DEVELOPMENT REVIEW BOARD

Code Enforcement Comments

PR-2019-002089

SD-2019-00196 – PRLEIMINARY/FINAL PLAT

SKETCH PLAT OF  
 LOT 19A-P1-A  
 SUNSET FARM SUBDIVISION  
 UNIT 2  
 SITUATE WITHIN  
 PROJECTED SECTION 24, T. 10 N., R. 2 E., N.M.P.M.  
 TOWN OF ATRISCO GRANT  
 CITY OF ALBUQUERQUE  
 BERNALILLO COUNTY, NEW MEXICO  
 JULY 2022

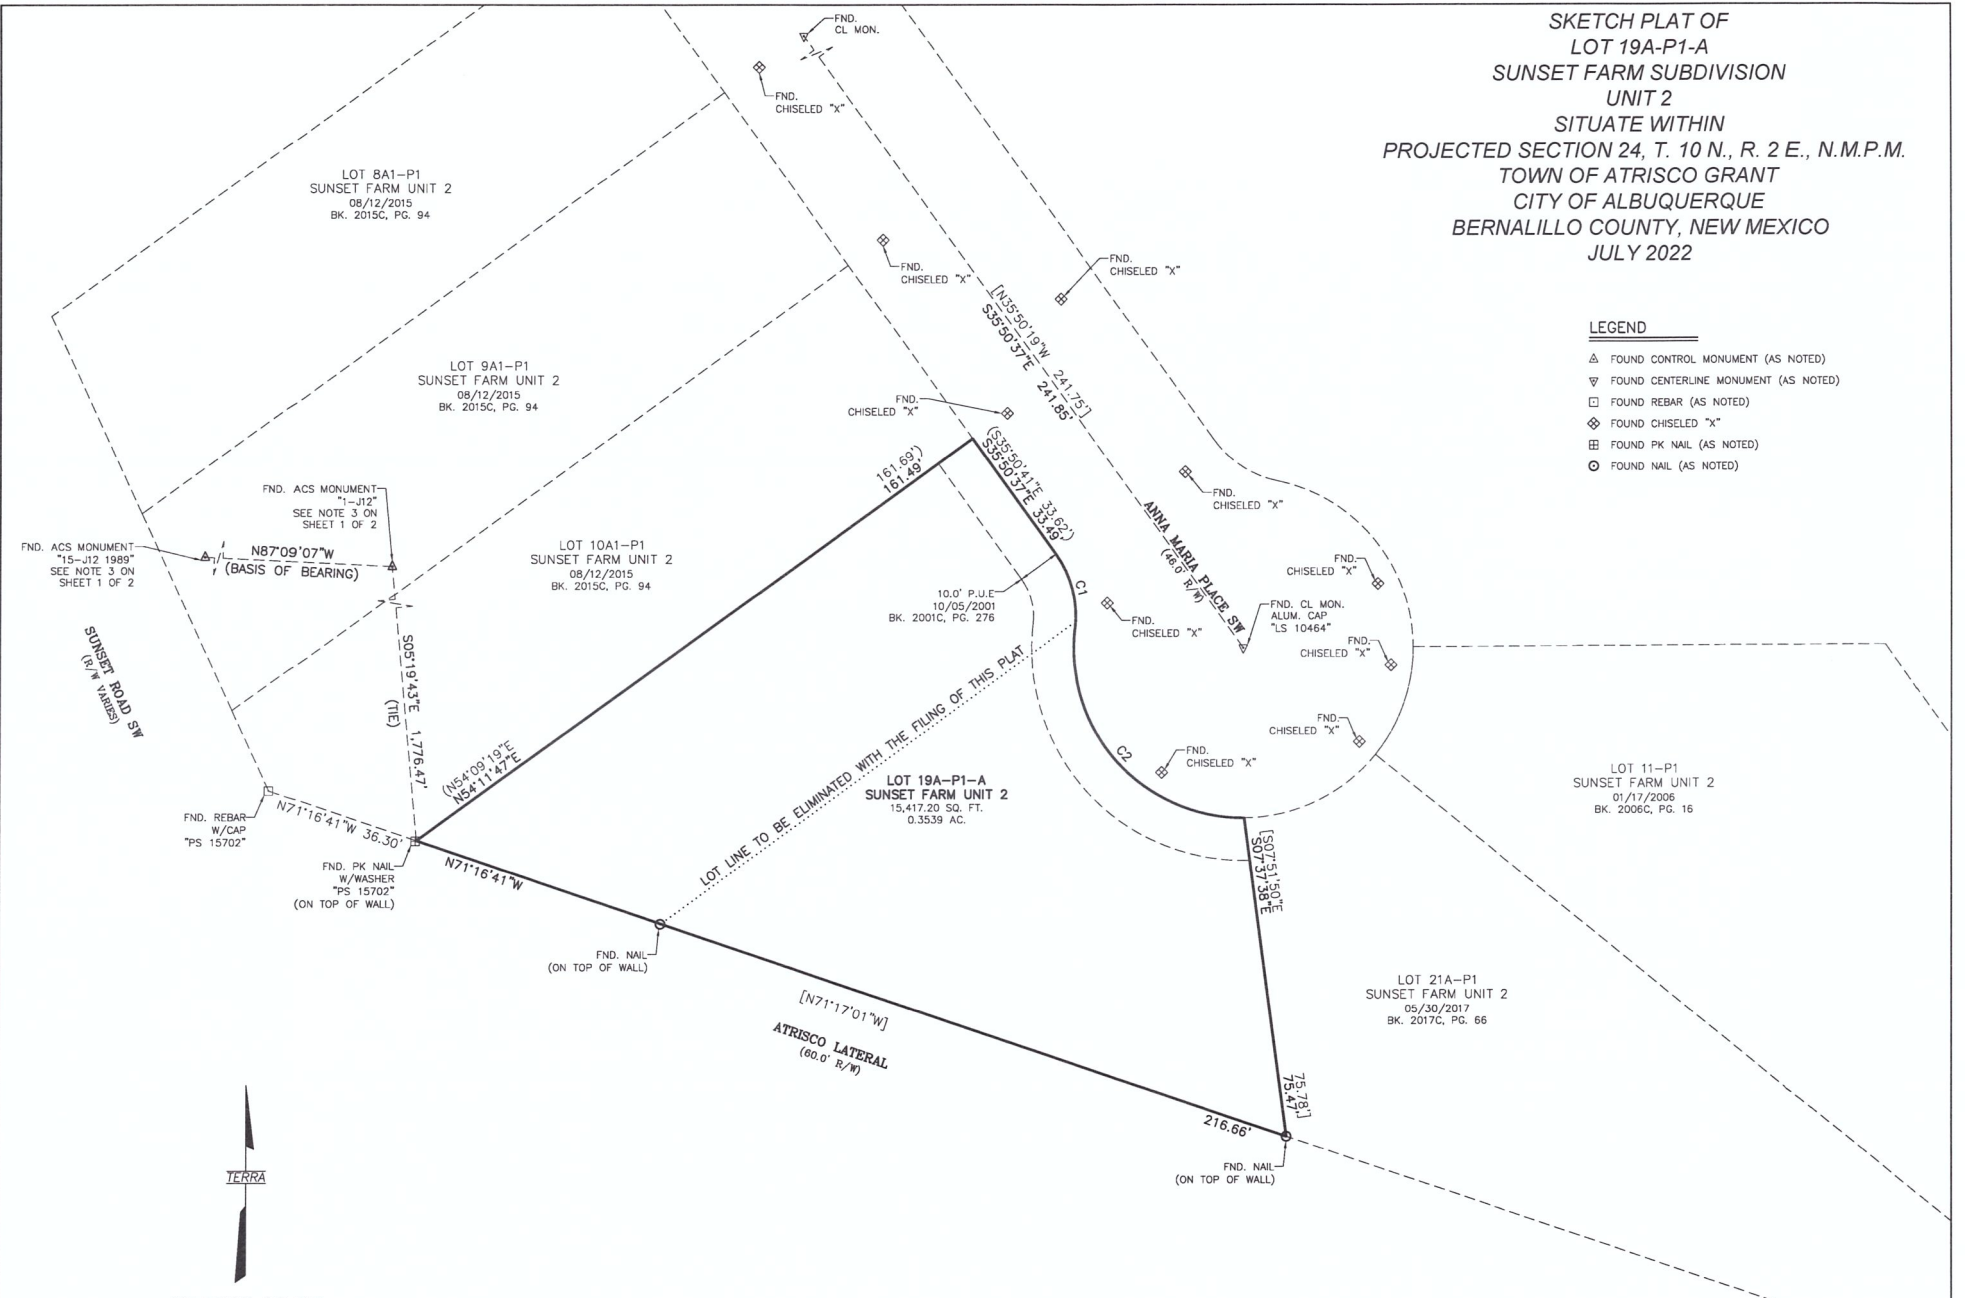
3. Proposed combined lot size is 0.3539 acre, which exceeds the allowed size range, from 75% at 0.1369 acre to 150% at 0.2738 acre.. This would require a Variance for the difference above the allowed lot size (.3539 acre - .2738 acre = **.0801 acre variance**).

4. Property owner has obtained the required Variances for the Contextual lot size for both lots, as per documentation provided in the submittal.
5. A note should be added to the plat regarding the Variances obtained, and citing Variance case numbers.

- Minimum lot size allowed, at 75% of 0.1825 acre = 0.1369 acre*
 - Maximum lot size allowed, at 150% of 0.1825 acre = 0.2738 acre*
- 10. Proposed combined lot size is 0.3539 acre, which exceeds the allowed size. Prior to replat, you must obtain a Variance for the difference above the allowed lot size (.3539 acre - .2738 acre = .0801 acre variance), as per IDO section 5-1(C)(2)(b)(3).*
- 11. CE has no further comments.*
